Components Division
Dunn NC #2383
200 Emmett Rd, Dunn NC 28334
910-892-8400

8/12/22

After reviewing the information, this letter is to address the concern about the roof trusses at 102 Birchwood Grove, for KB Homes.

102 Birchwood Grove  
KB Homes

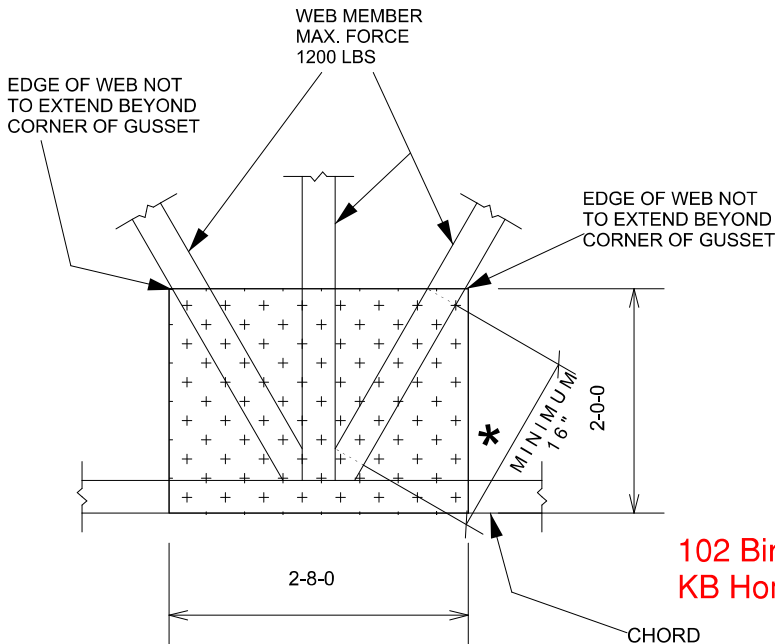
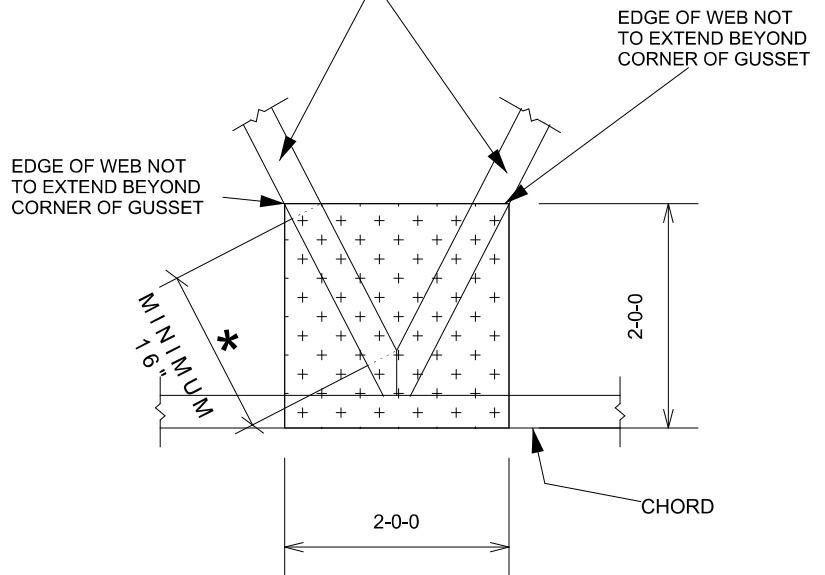
The repair of $\frac{3}{4}$ " OSB on both sides of the damaged truss is not affected in any way with the modification observed on site to accommodate electrical run. Truss will perform as designed. Please reach out if any other information is required.
